CITY OF ALBUQUERQUE

December 10, 2025

RE: ALOFT HOTEL
1501 Aircraft Ave SE
Grading & Drainage Plans
Engineer's Stamp Date: 10/30/2025
Hydrology File: M15D057
Case # HYDR-2025-00219

15 - GRADING PLAN - SOUTH

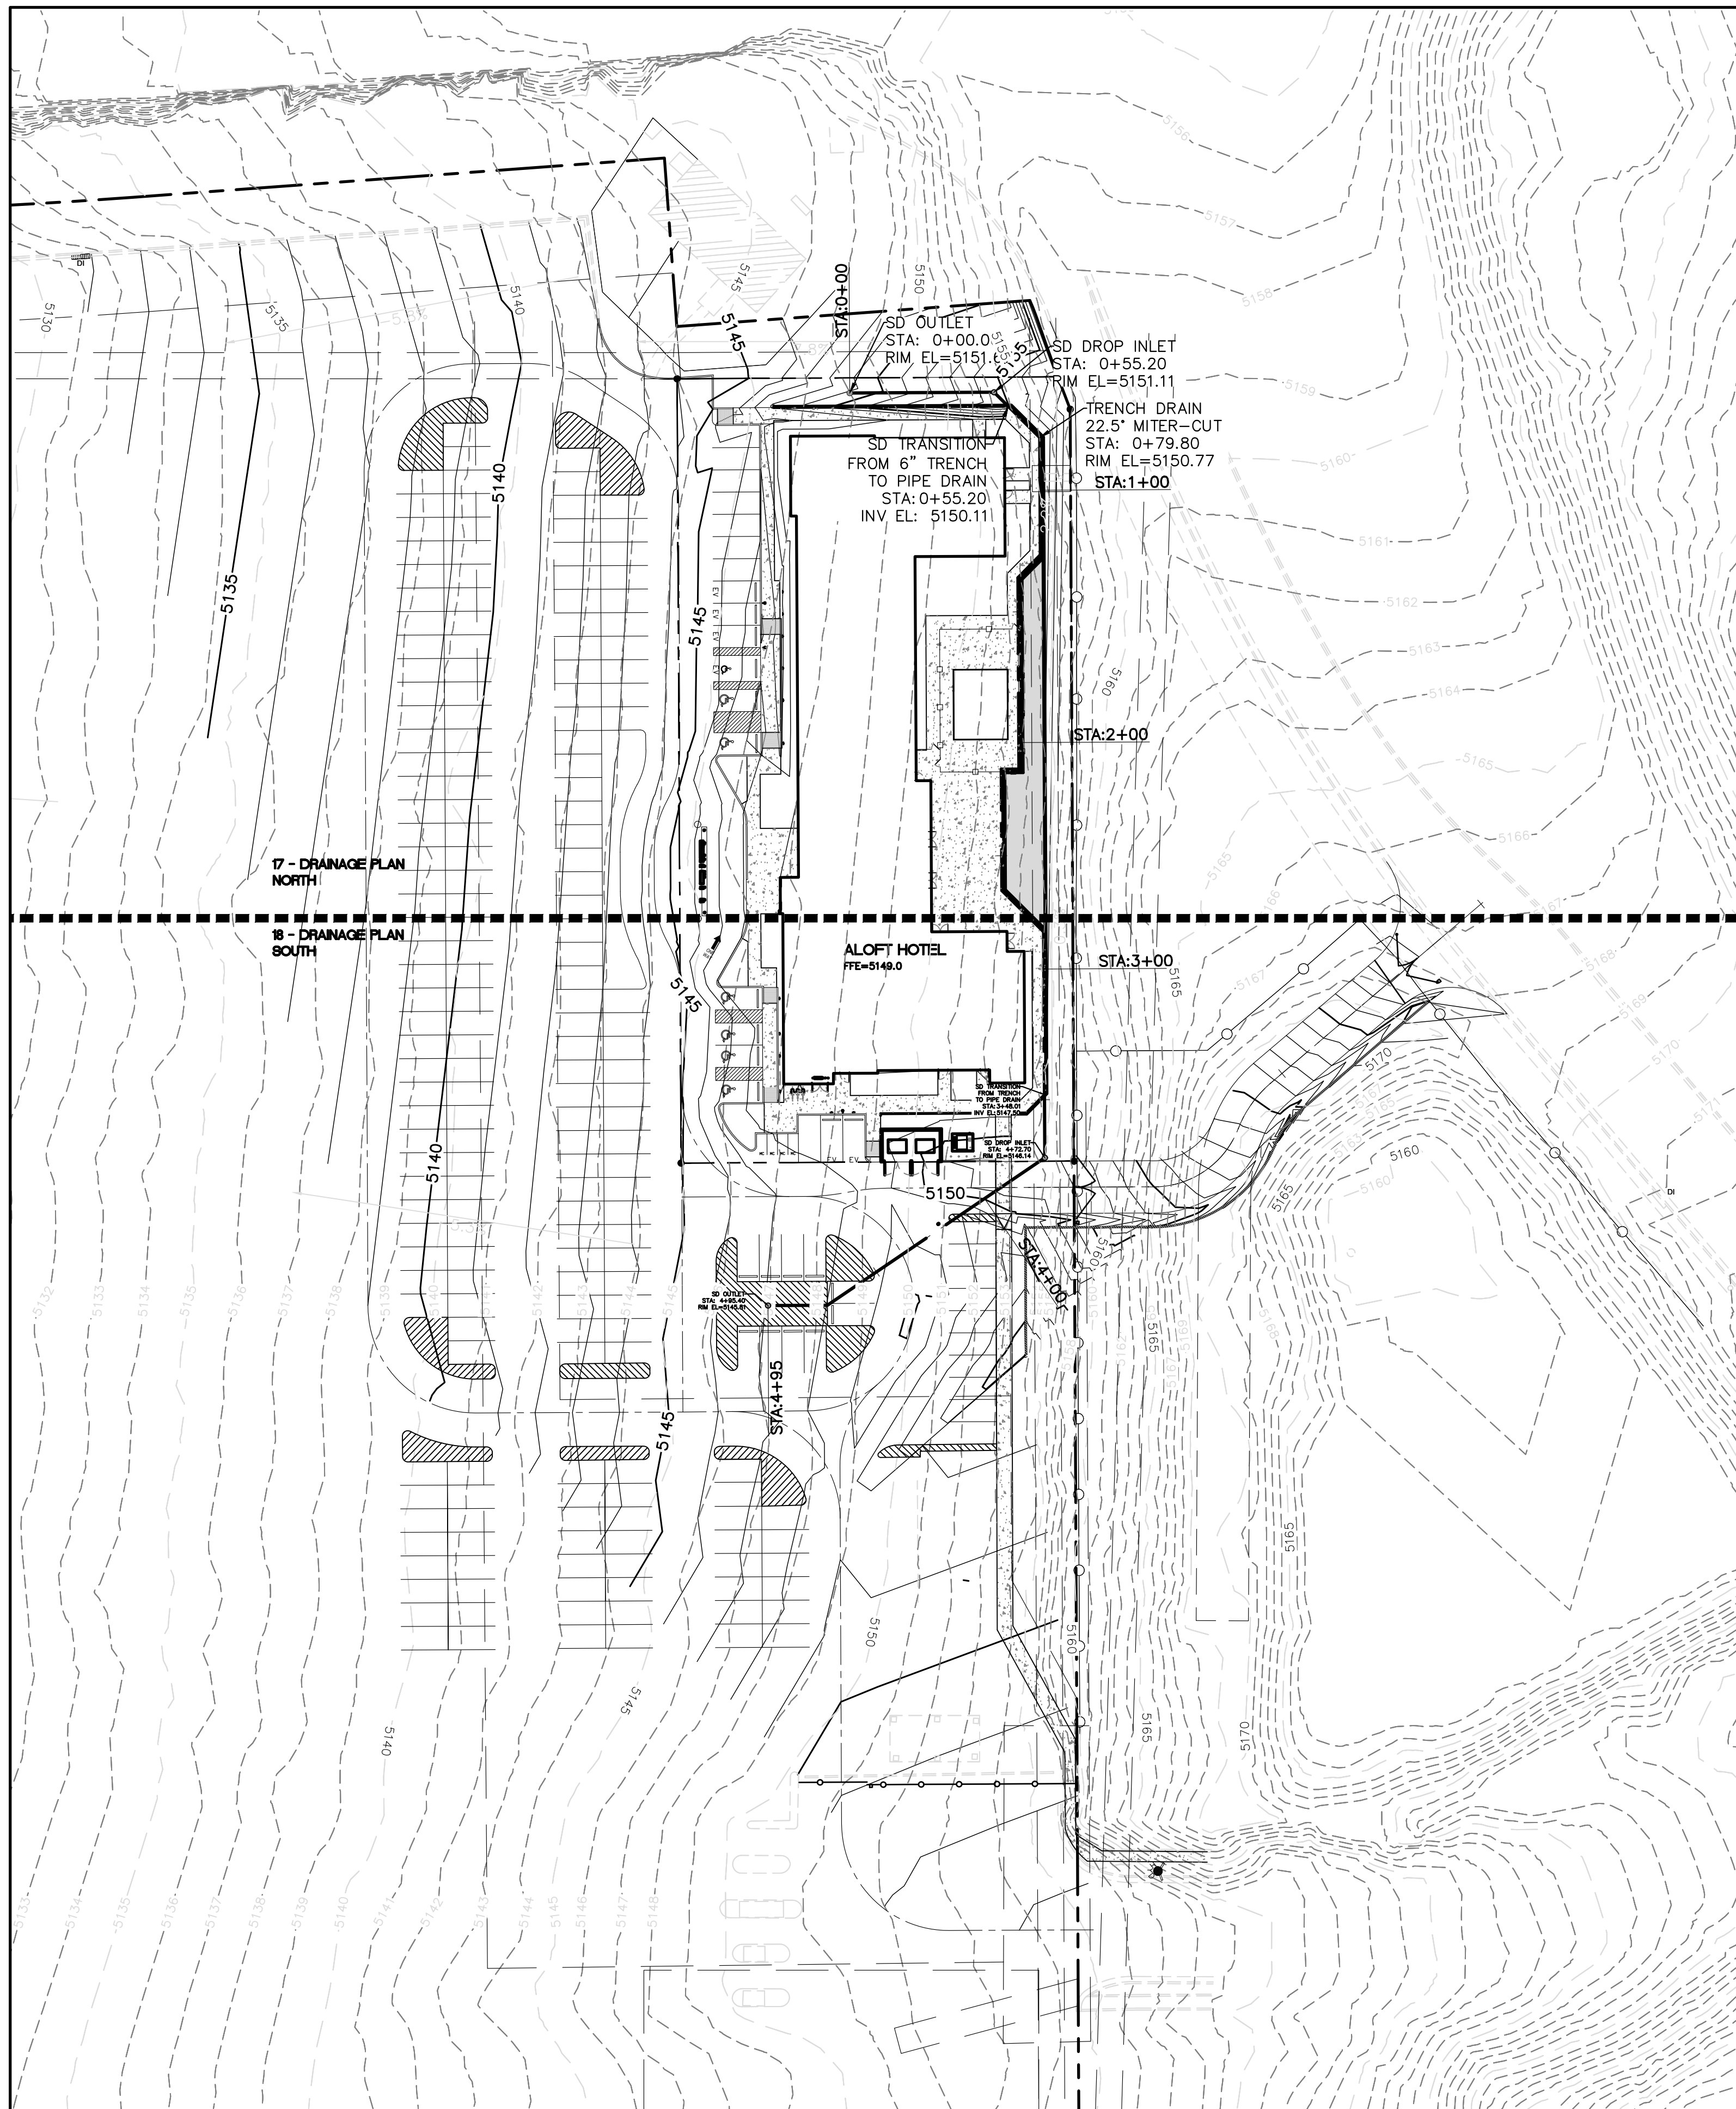
1. The proposed contours on the bottom of the emergency access road east of the hotel show 15' of excavation on top of the existing city-owned dam, which will result in excessive off-site stormwater entering the Hotel construction area with the removal of the dam. The proposed contours don't tie into existing contours, leaving a 15' high slope unaccounted for. The limits of disturbance can't be identified until the proposed contours are tied into the existing contours. Please submit a revised G&D Plan showing the corrected contours to Hydrology for re-approval.

3. Provide details for the retaining wall south of the emergency access road and east of the hotel parking lot.
4. Provide pond storage capacity, WSEL/Free Board analysis for the existing City pond.
5. Add a water block at the University Blvd. connection.
6. The hotel property owner needs to get an access easement from the City and signs a maintenance agreement with the City.

SCALE: 1"=20'

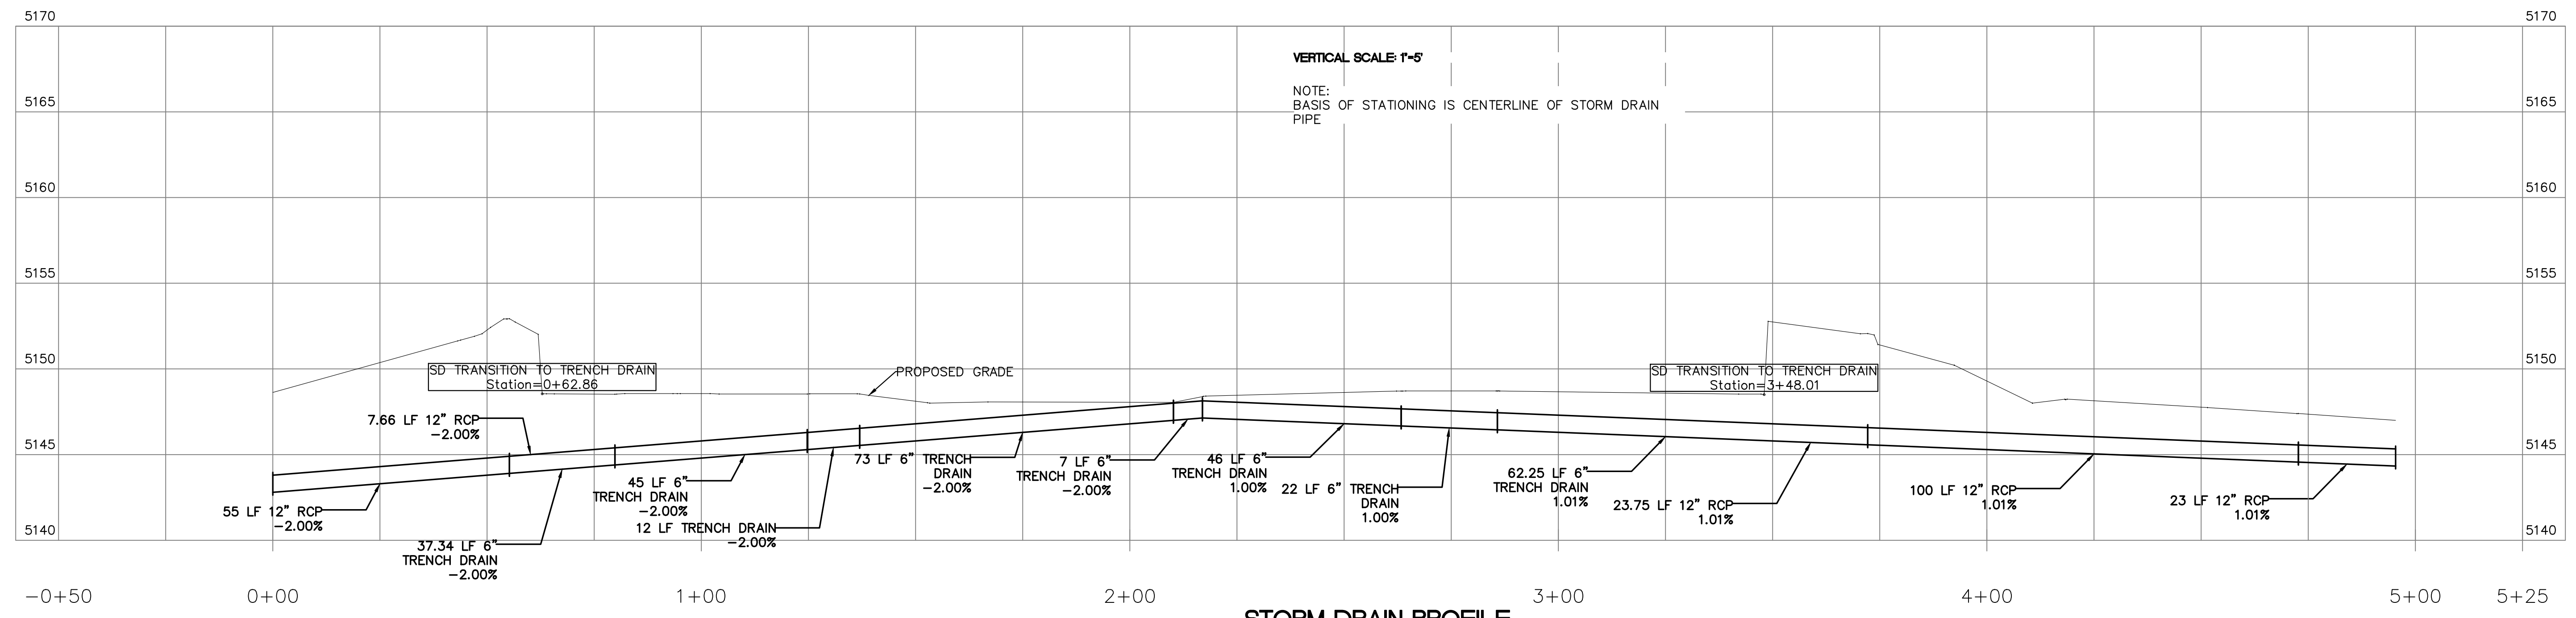
2. Show the existing 36" RCP SD location.
